Conservation Area Advisory Committee

Meeting Date : 2 March 2015

FRONT ELEVATION (SOUTH) PROPOSED 1:100.

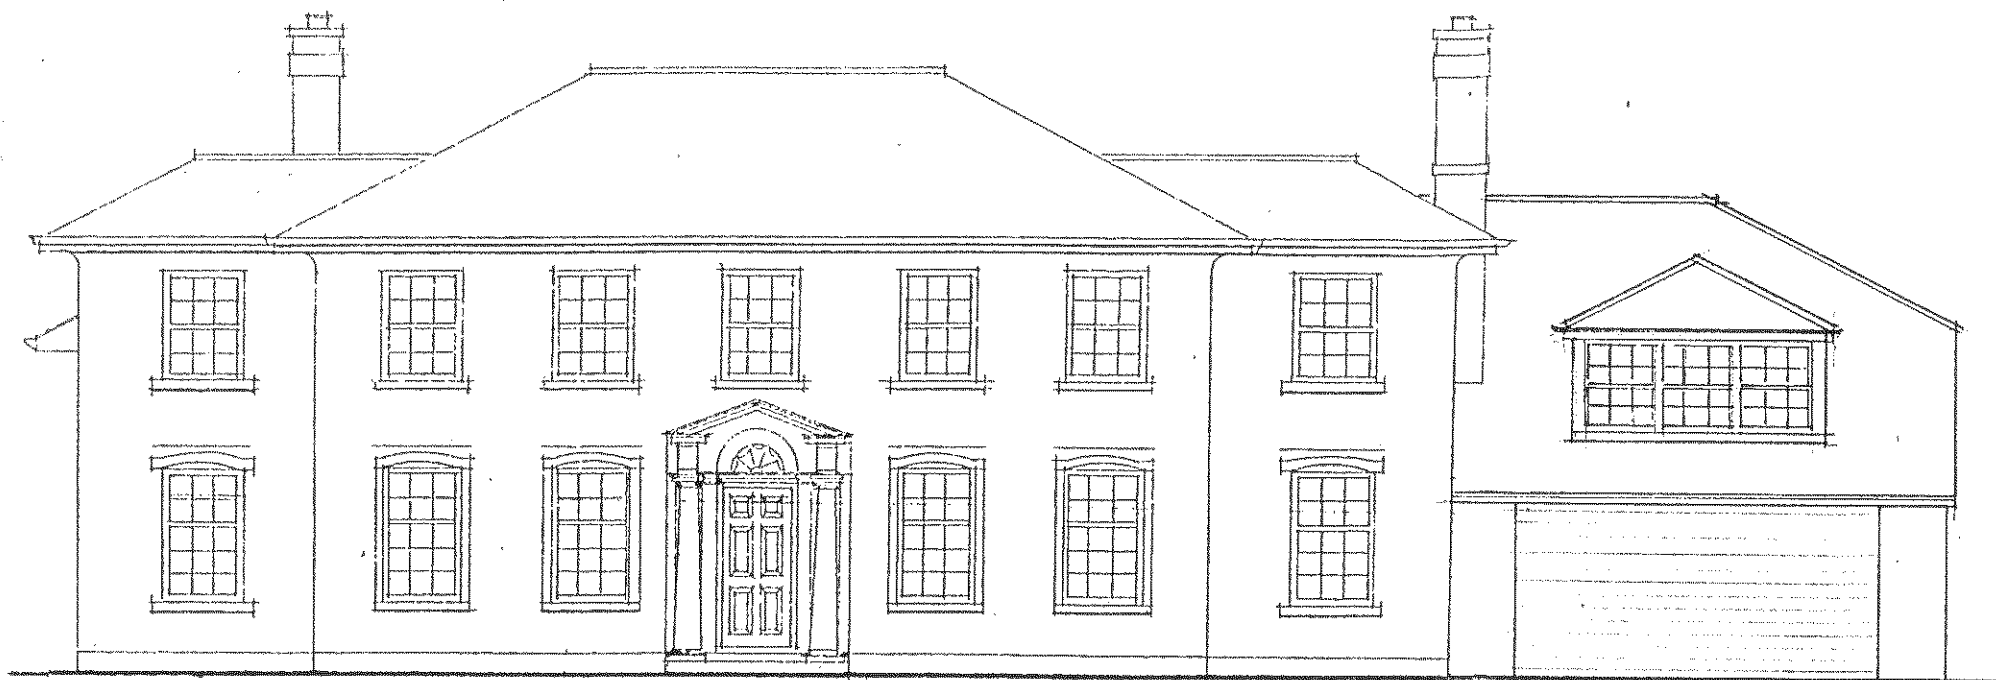
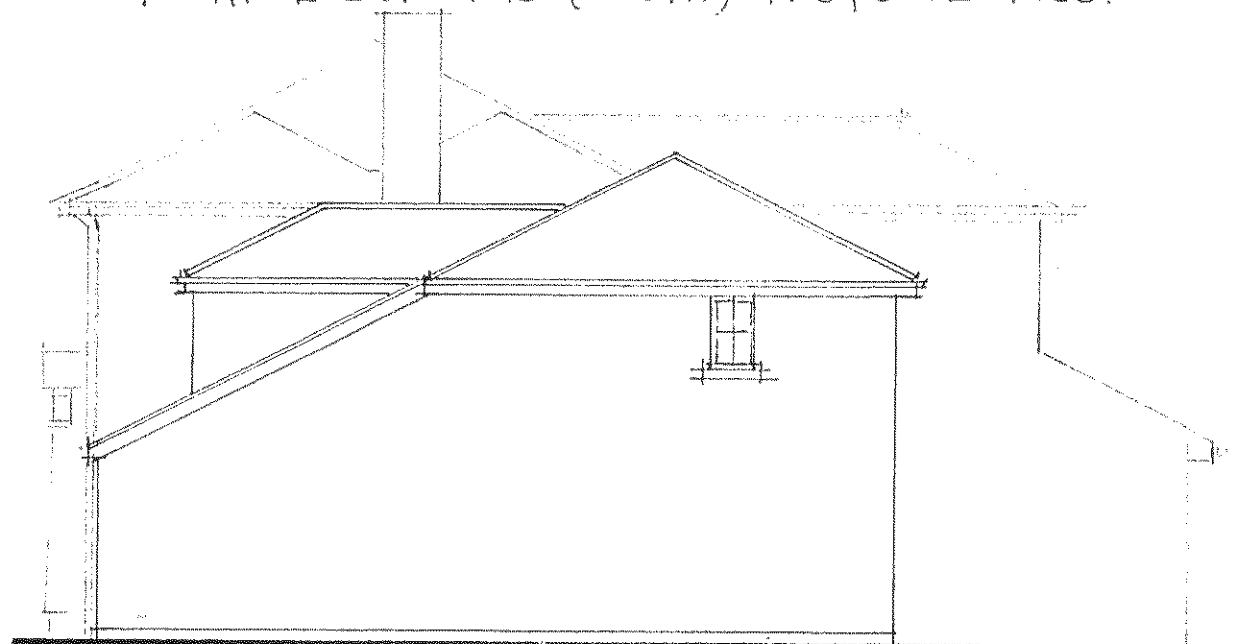
Ref	Description	Address	Design award
AW/360/14/HH	Side extension for garage & store with guest suite over. This application affects the character & appearance of the Aldwick Bay Conservation Area.	91 The Fairway Aldwick	RL
Comments: Strong objection Suggested Conditions: Detracts from the main dwelling. No sympathetic to the original structure			
AW/6/15/HH	Proposed first floor extension. This application affects the character and appearance of the Aldwick (Craigweil House) Conservation Area	81 Barrack Lane Aldwick	RL
Comments: Comment Suggested Conditions: We feel that the design of the front elevation detracts from the Conservation Area and suggest that any new design to make it more attractive.
